WEST SUSSEX COUNTY COUNCIL CONSULTATION

TO:	Arun District Council FAO: Amy Myer
FROM:	WSCC - Highways Authority
DATE:	4 October 2021
LOCATION:	Tile Barn Farm, 32 Hill Lane, Barnham, PO22 0BL
SUBJECT:	BN/126/21/DOC Approval of details reserved by condition imposed under ref W/4001228 (BN/24/20/PL) relating to Condition Nos 3 - materials and finishes, 5 - noise, 6 - dustbin enclosure, 7 - renewable energy, 10 - covered & secure cycle parking, 11 - electric vehicle charging, 12 - surface water drainage and 13 - foul drainage.
DATE OF SITE VISIT:	N/A
RECOMMENDATION:	Advice
S106 CONTRIBUTION TOTAL:	N/A

SITE PLAN

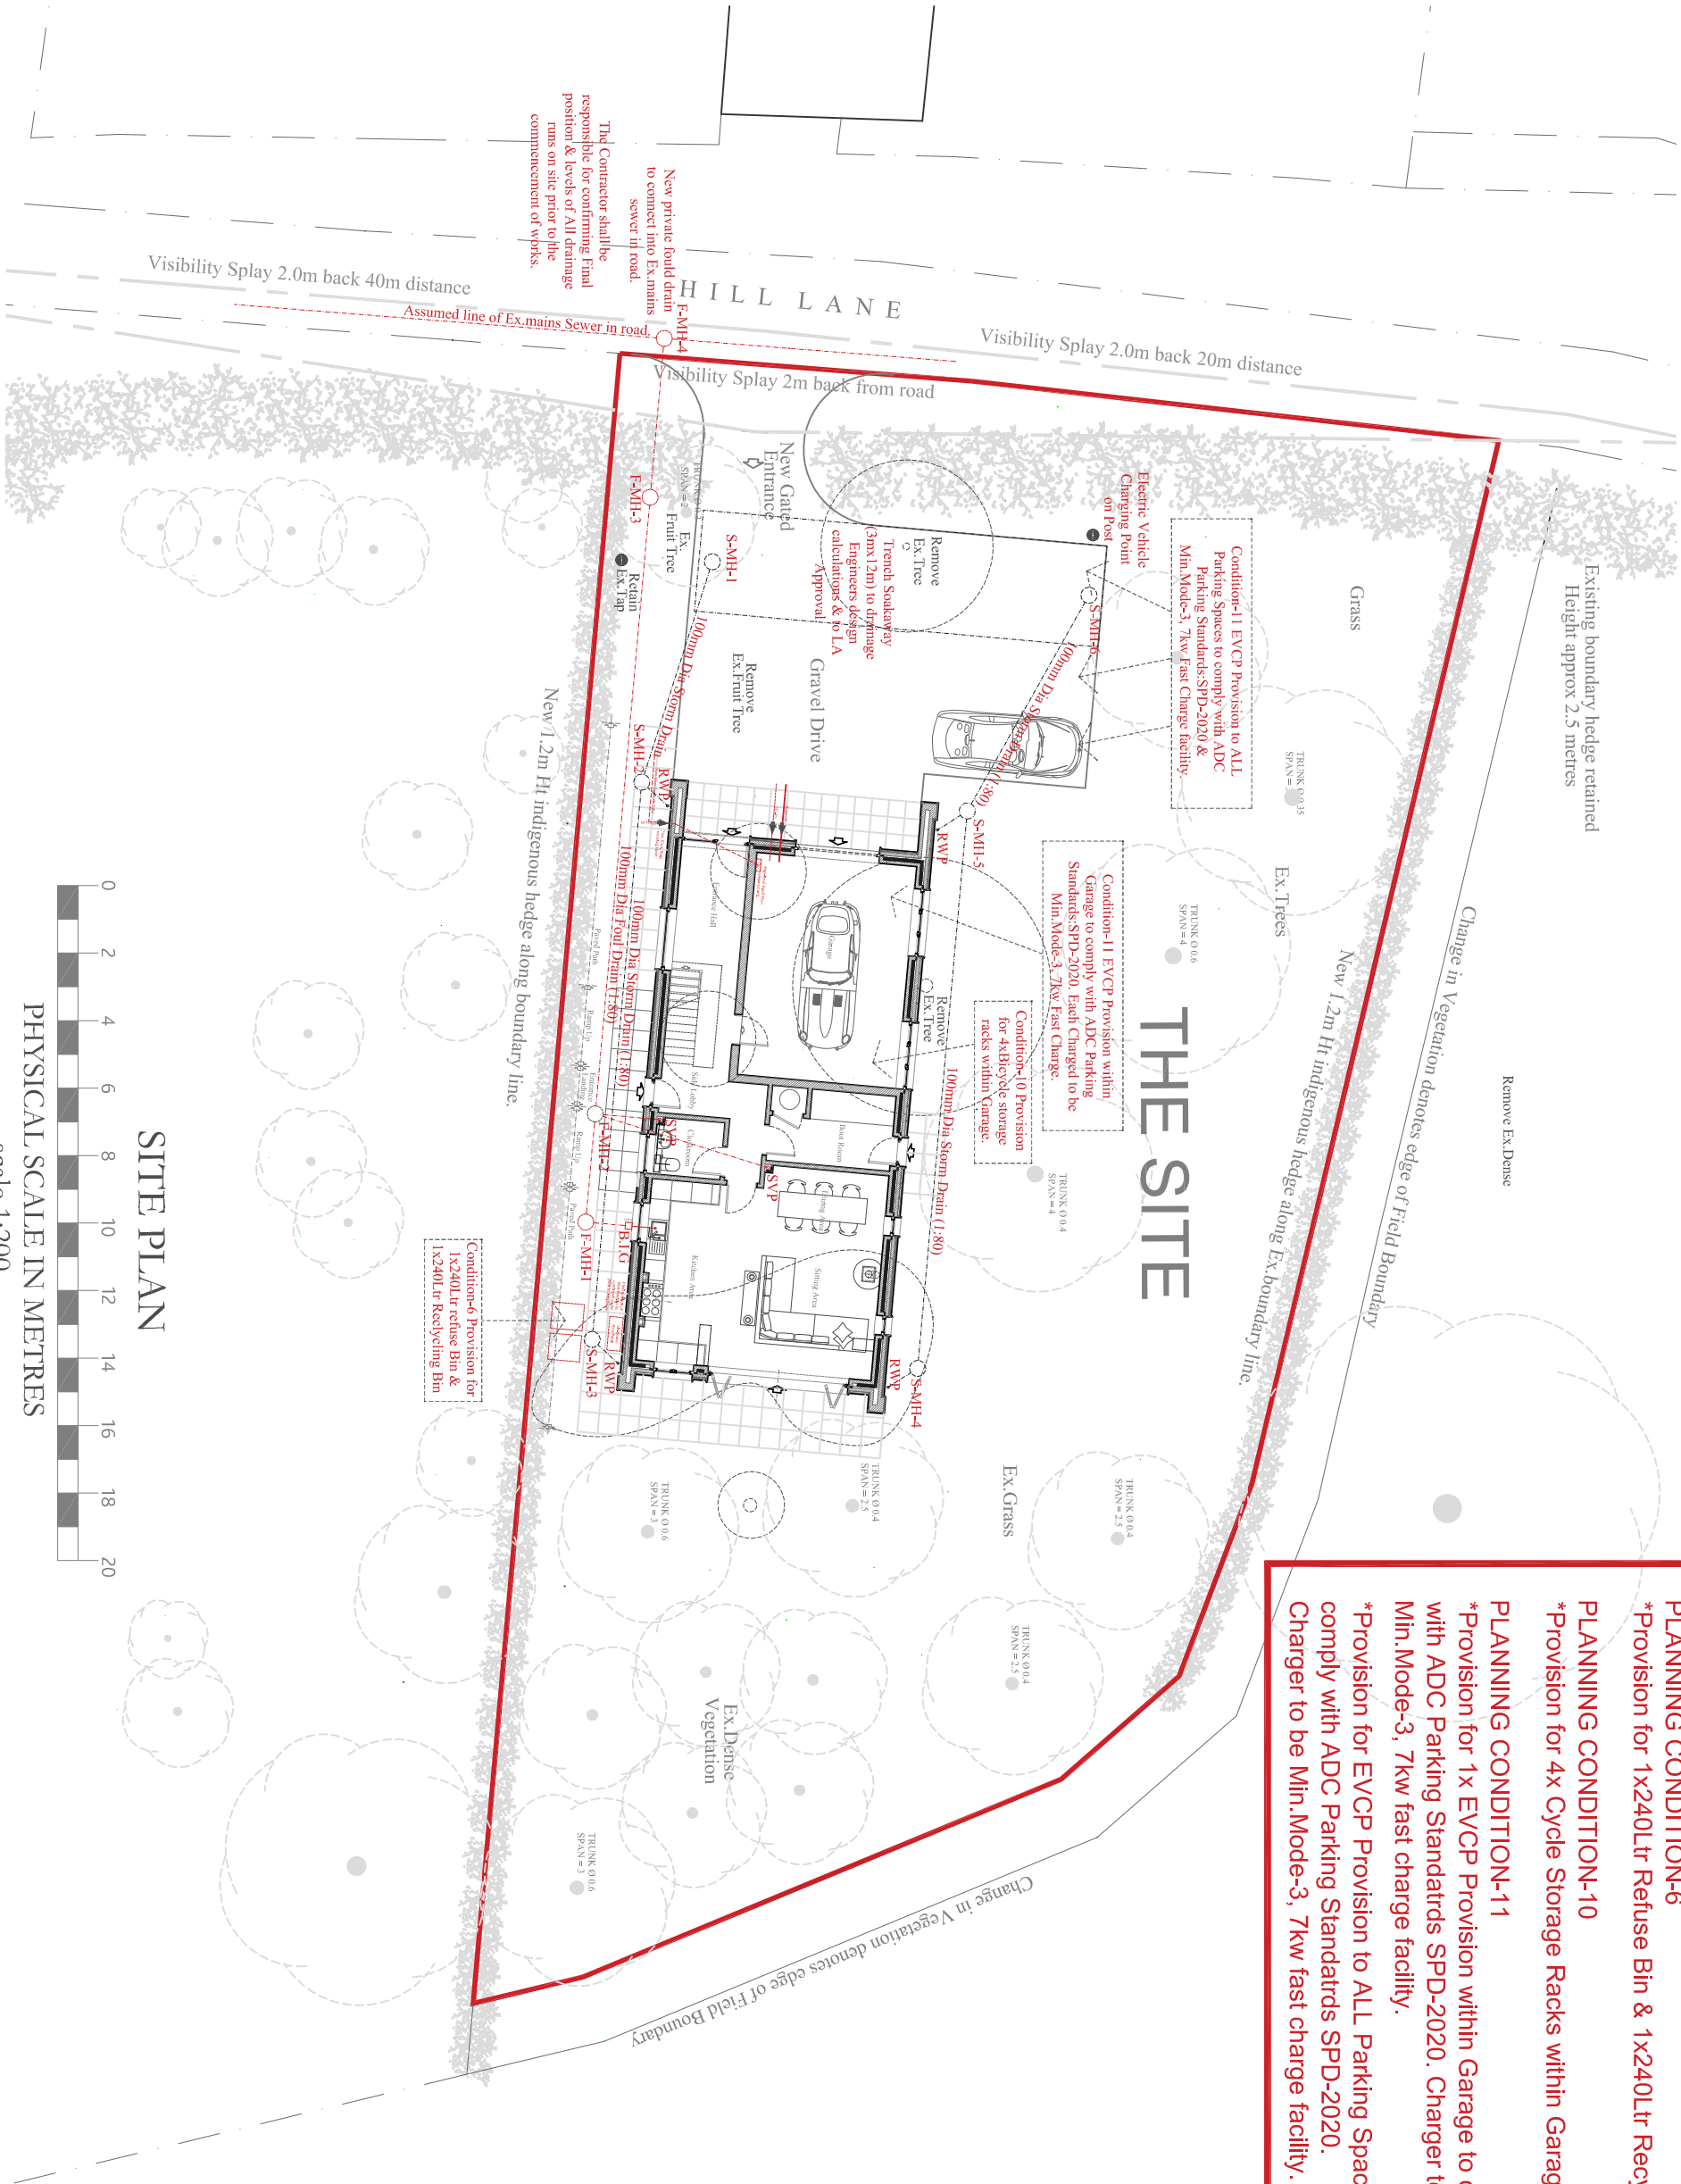
The Covering Letter states that the proposed garage will be utilised for the covered and secure parking of cycles. From inspection of the plans, the proposed garage will have approximate internal specifications of 4.7m x 6.6m, which is of sufficient size to be considered for cycle parking provision by the LHA.

In conclusion, the LHA is satisfied that Condition 10 can be discharged.
